**RE: 130 Eastern Promenade, Project ID 2011-258**

**Project Memo: 130 Eastern Promenade**

**RE: Response to Staff Comments**

Drawing Title: SITE LAYOUT & MATERIALS PLAN

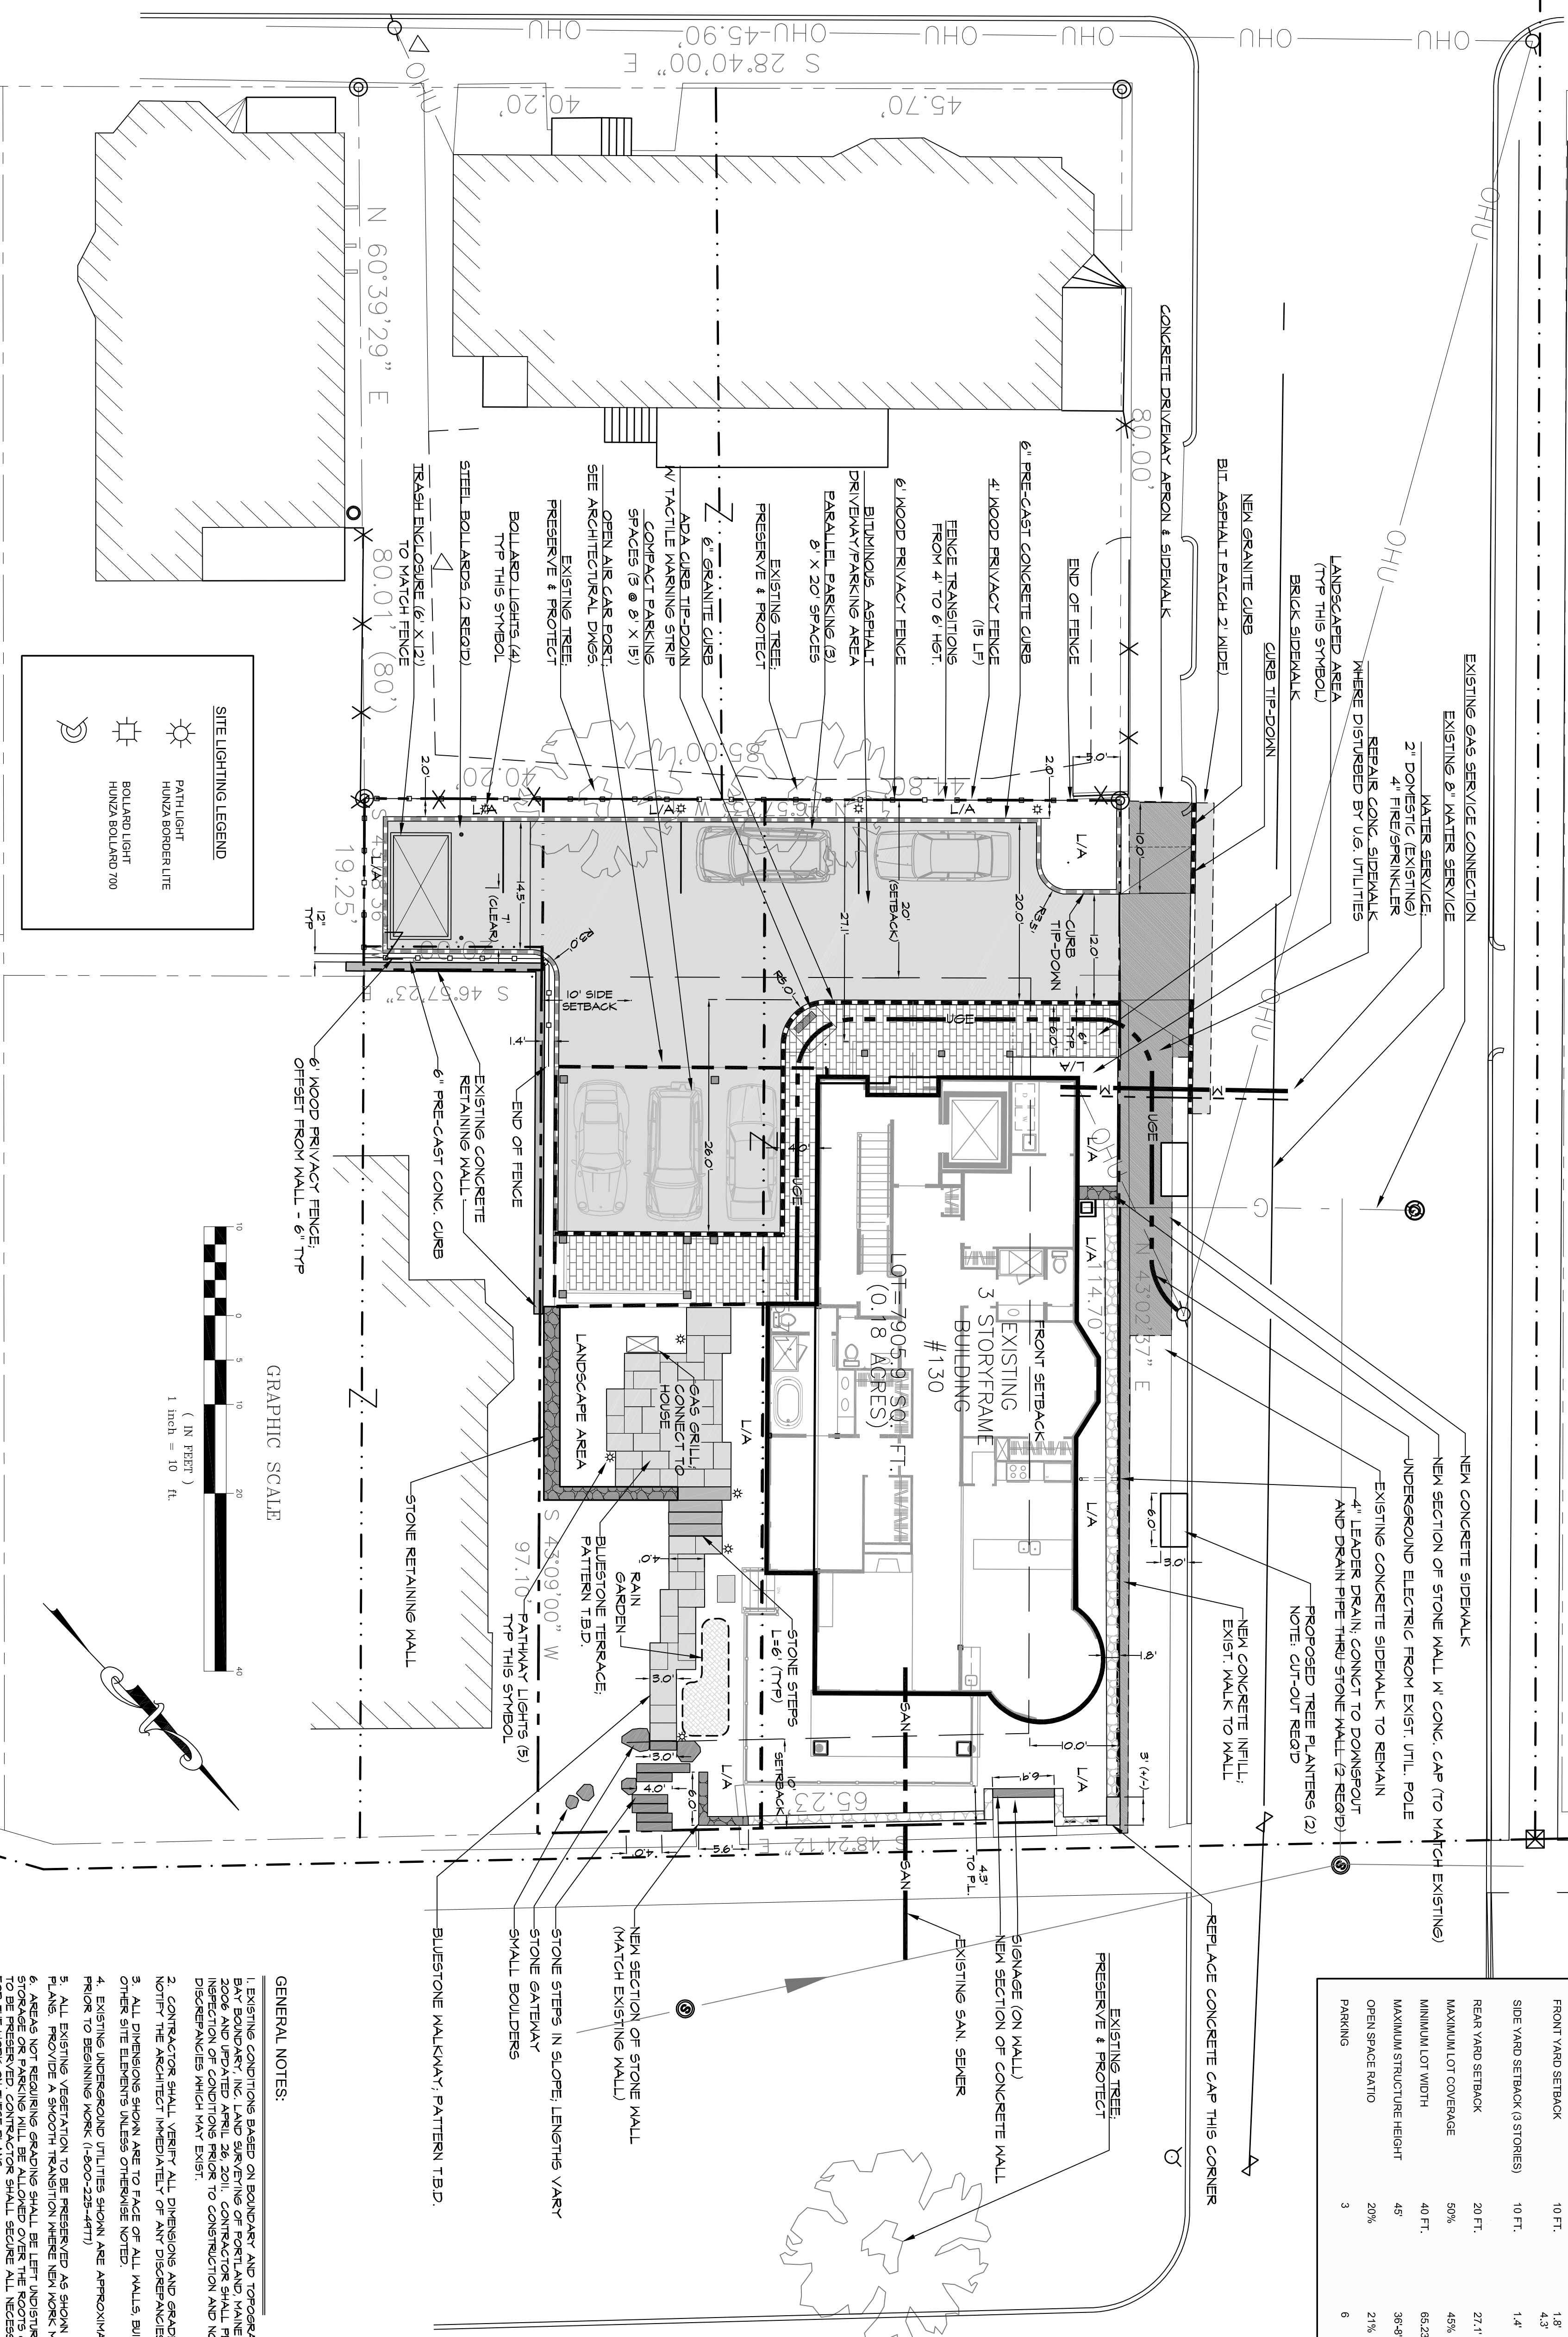
Response: Catalog cuts and photometrics for all proposed lighting are attached to this response m
7. The site plan shows two up-lights at the entrance of the building on Eastern Promenade, up-lighting is prohibited, please refer to 14-526 (d) (6) (b):  
Up-lighting by any method is prohibited except for public buildings and parklands, clock towers and steeples, landscape features, designated historic landmarks, flags of state, federal or national jurisdictions, and public art. Such light fixtures, brackets, conduits and all other components shall be designed by a lighting professional and shall be scaled and placed to minimize their visibility and installed in accordance with the standards contained in Section 12 of the Technical Manual.

Response: We agree and the uplight has been removed from the proposal.
8. Show bike and motorcycle parking on the site plans.  
Response: Bicycle storage is proposed to be located within the enclosed portion of the carport in front of the 3 parking spaces. It is identified as #17 on sheet A-1. No scooter parking is proposed for this project.

4. The use of compact parking spaces for the proposed lot does not meet City standards. The applicant should formally request a waiver. I support use of compact spaces.

5. The standard parking spaces proposed for the site do not meet City standards. The spaces are proposed to be 8’x20’. The applicant should formally request a waiver and note why the standard can’t be met.

6. The proposed parking circulation aisle width does not meet City standards. The applicant should formally request a waiver.

8. Access into and out of the parking space near the trash enclosure will be very difficult. The applicant should provide information that the noted space is reasonably accessible.

**Response:** The proposed parking space is 8 ft x 20 ft are proposed as parallel spaces along the side of the driveway. The proposed dimensions allows for a full 12 ft driveway width as well as a 2 foot landscaped zone between the parking and property line, which accommodates a wooden fence and bollard lighting. The dimensions indicated are standard dimensions for parallel parking. A formal waiver request is noted in the cover letter.

7. **Response:** The driveway aisle is 12 feet wide with parallel spaces as it enters the property and extends past the proposed building entrance. At the carport the aisle width widens to 23 feet. We believe the drive and aisle provides adequate maneuvering room given the small number of vehicles it accommodates. A formal waiver request is noted in the cover letter.

**Response:** We have revised the location of the Trash Enclosure to provide additional maneuvering space around the end parking space, which now allows approximately 25 feet of length to pull up and back the vehicle into the space. We believe this provides a reasonably accessible parking arrangement and also makes the trash enclosure more accessible for residents. We will follow up with a turning diagram if desired by Staff.

Drawing Title: LANDSCAPE PLAN

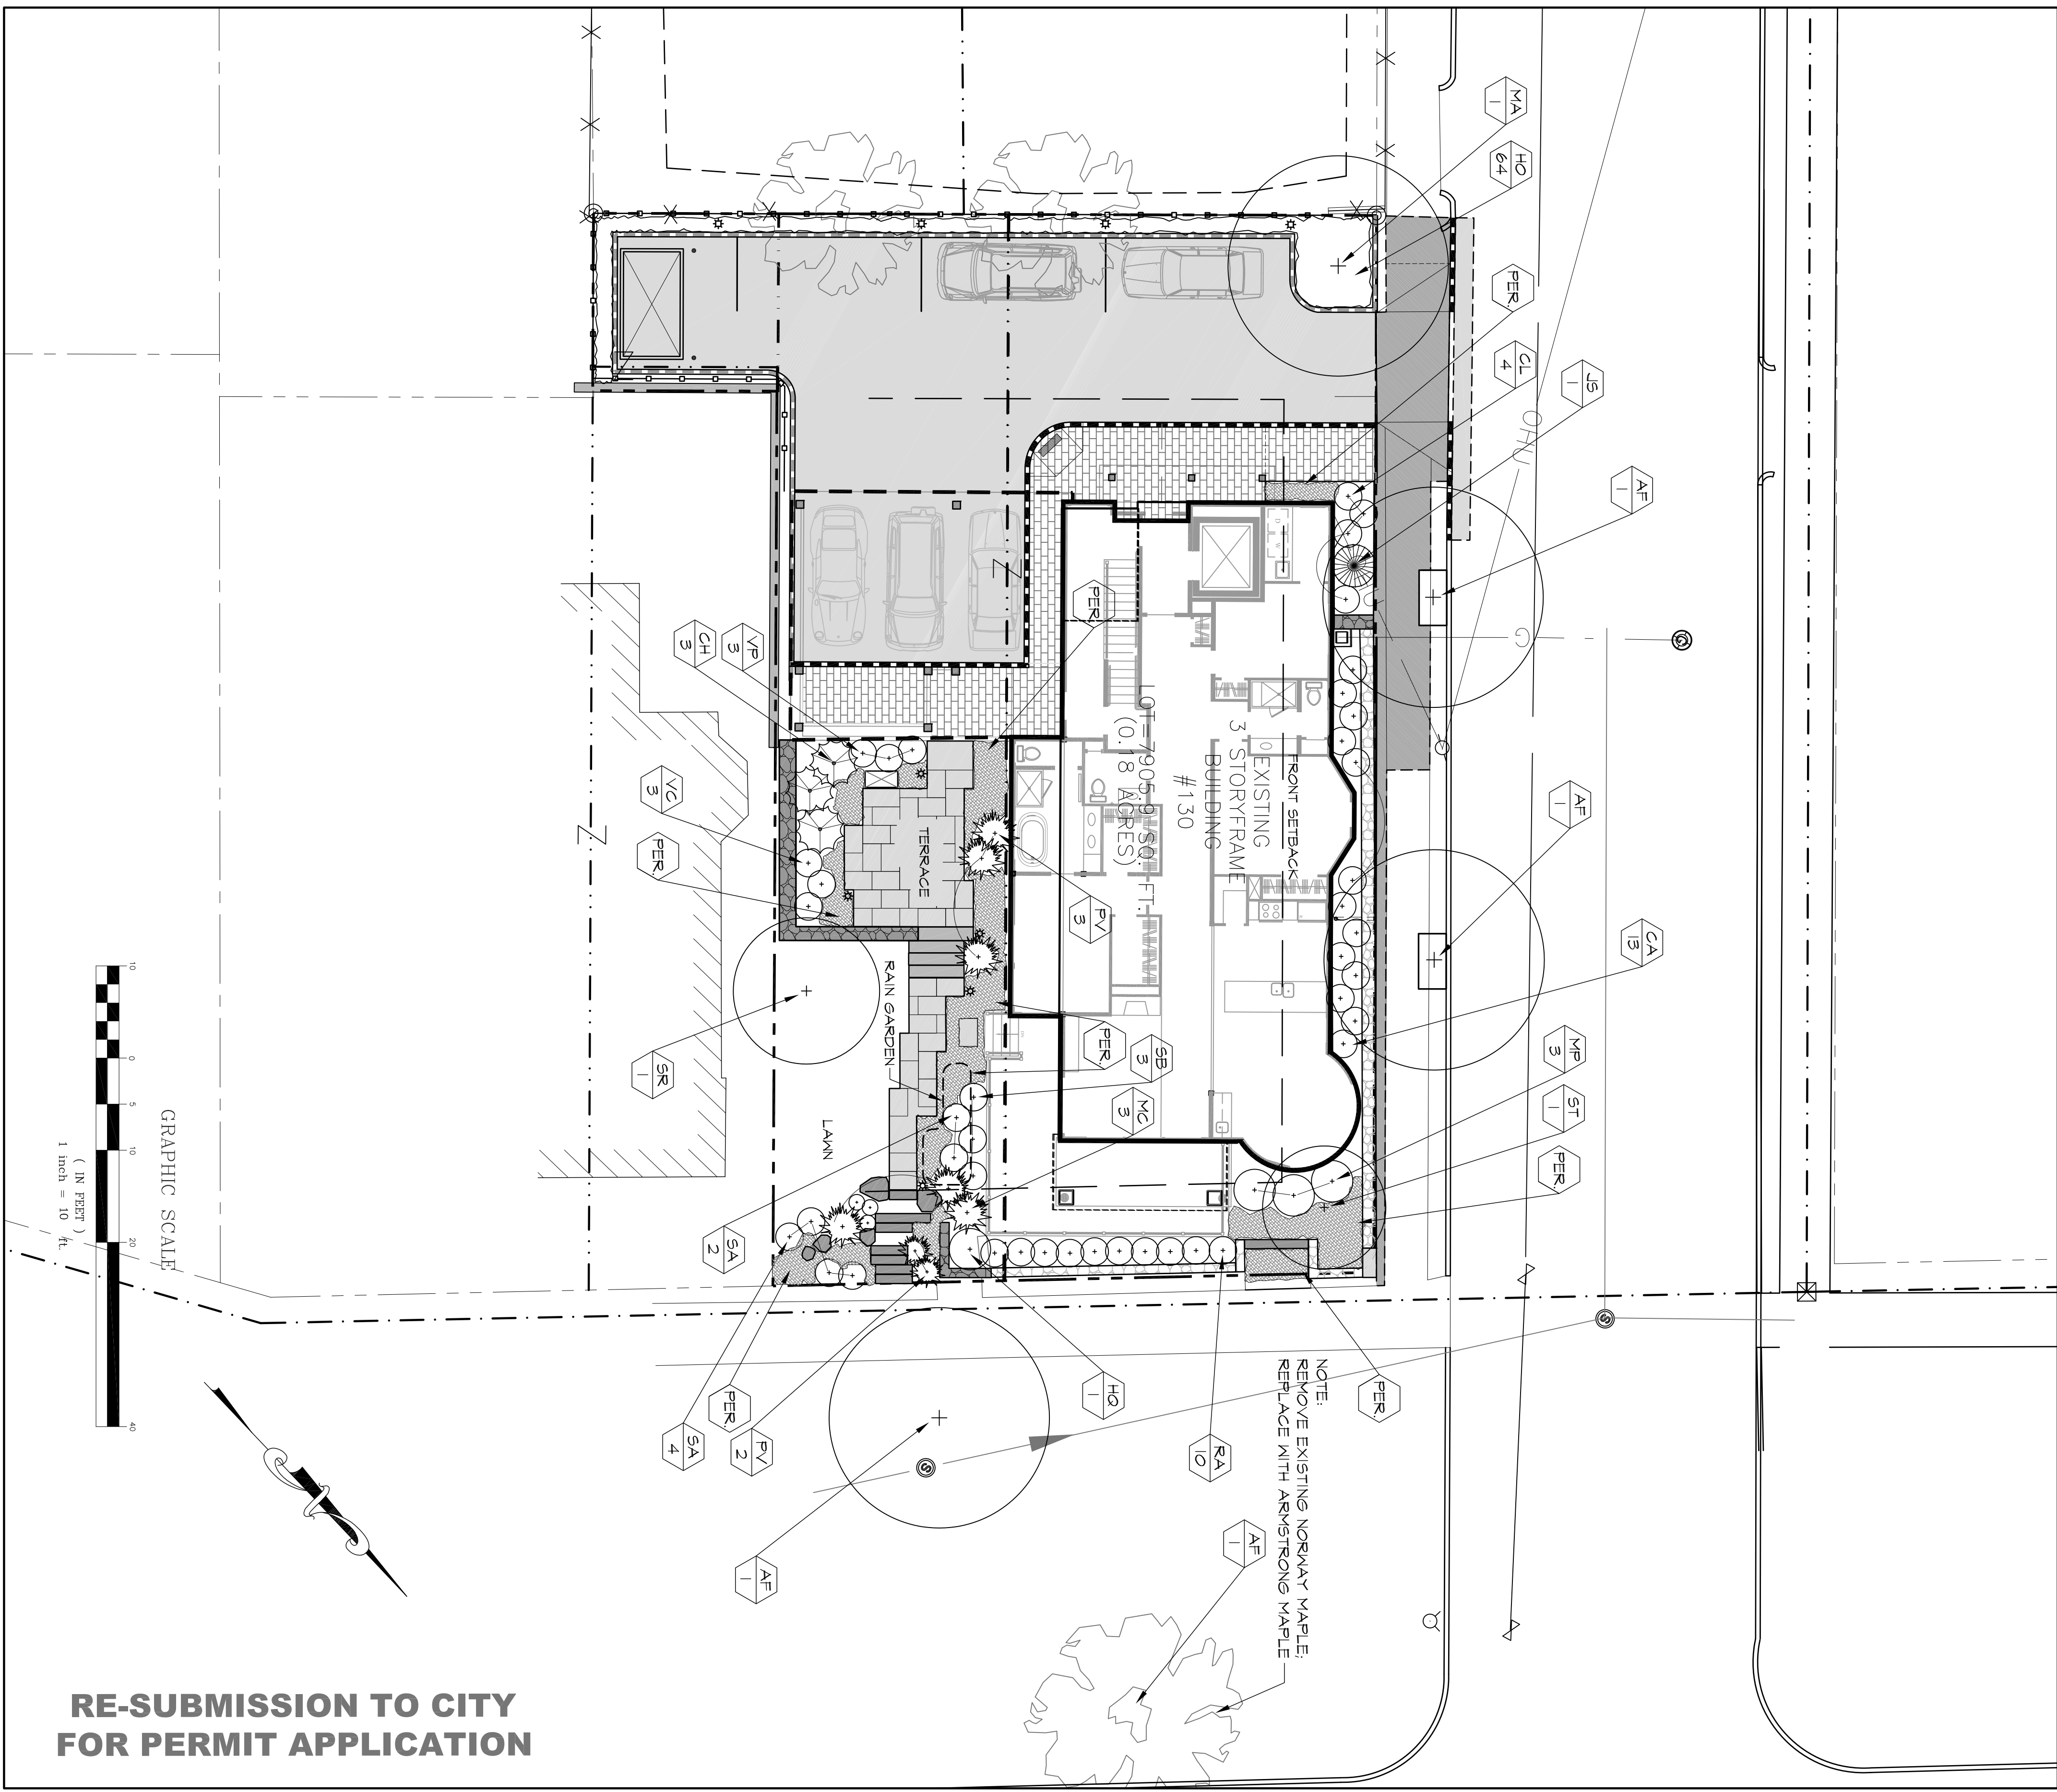
1. I have reviewed the proposed 130 Eastern Promenade Conversion project, overall the landscape plan is acceptable as shown with the following conditions / recommendations: that the two 'Cleveland Pears' shown as street-trees on Wilson Street be changed to a different species, perhaps Amelanchier x grandiflora 'Princess Diana', single-stem, upright tree form or Malus x 'Adirondack', flowering Crabapple or similar type tree. We have had issues with all Callery Pears due to storm damage, especially on or near the Eastern Prom area.

2. The Eastern Promenade Master Plan specifies that an "Armstrong" Red Maple be planted along the Eastern Prom sidewalk across from, or near the corner of the existing building. The EP 'Street Tree Plan' acknowledges the balance between the historic alley of trees and desire for vistas. Thus tree selection for this area is "Armstrong" Red Maple that would have a narrow, upright form. The tree plan also considers the removal of existing Norway maple and replacement if desired. This could be worked out after the approval process.

**Response:** We agree that Cleveland Pear may be susceptible to storm damage and will modify the plan. We are proposing substituting Armstrong Red Maples to match trees planted along the Eastern Promenade (see response below)

**Response:** The Applicant would propose removing the existing Norway Maple and installing two Armstrong Red Maples along the Eastern Promenade, as recommended above by Mt. Tarling. Additionally, the Applicant would be amenable to replacing the next adjacent Red Norway Maple to the east, providing a total of 3 trees in the Promenade. This would provide a massing of new trees that gives some prominence and continuity to this corner.

12 STONE RETAINING WALL DETAIL

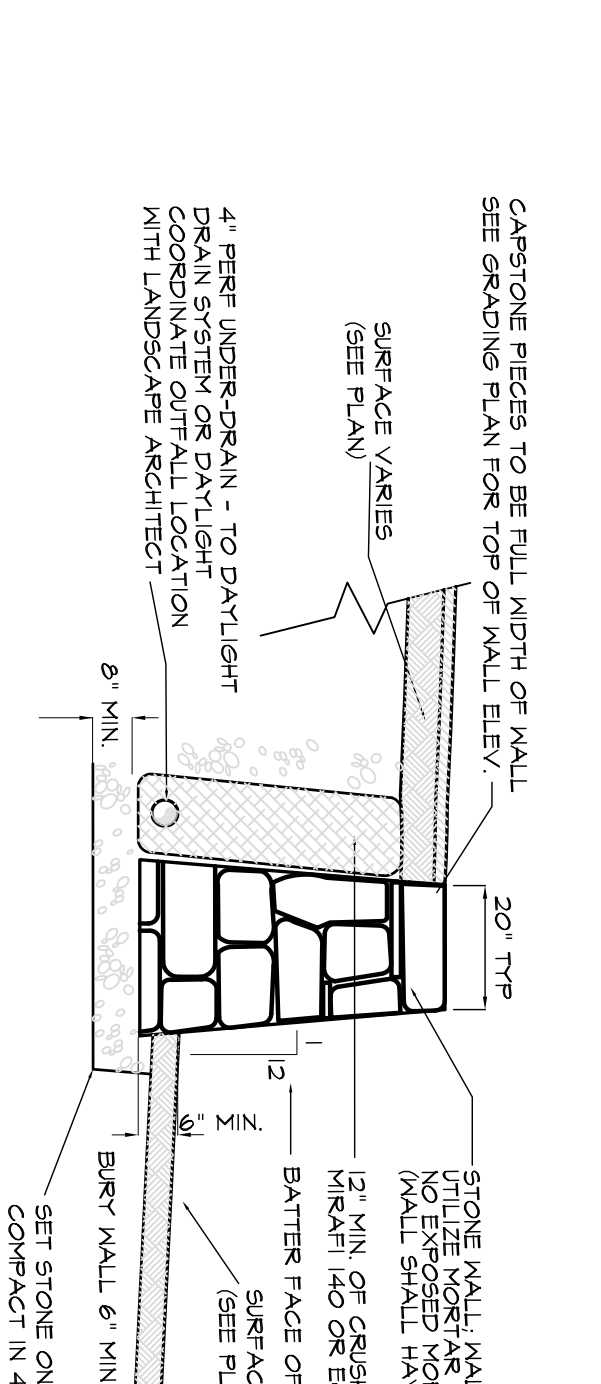
- iv. We are requesting a waiver from this standard for the very small increase we will be making to the City's stormwater system.
2. Retaining walls over four feet will need to have engineered details on the site plan.

Response: Proposed retaining walls do not exceed 3'-8" in height.
3. Provide more information on the proposed fence, i.e. color, material, typical, etc.
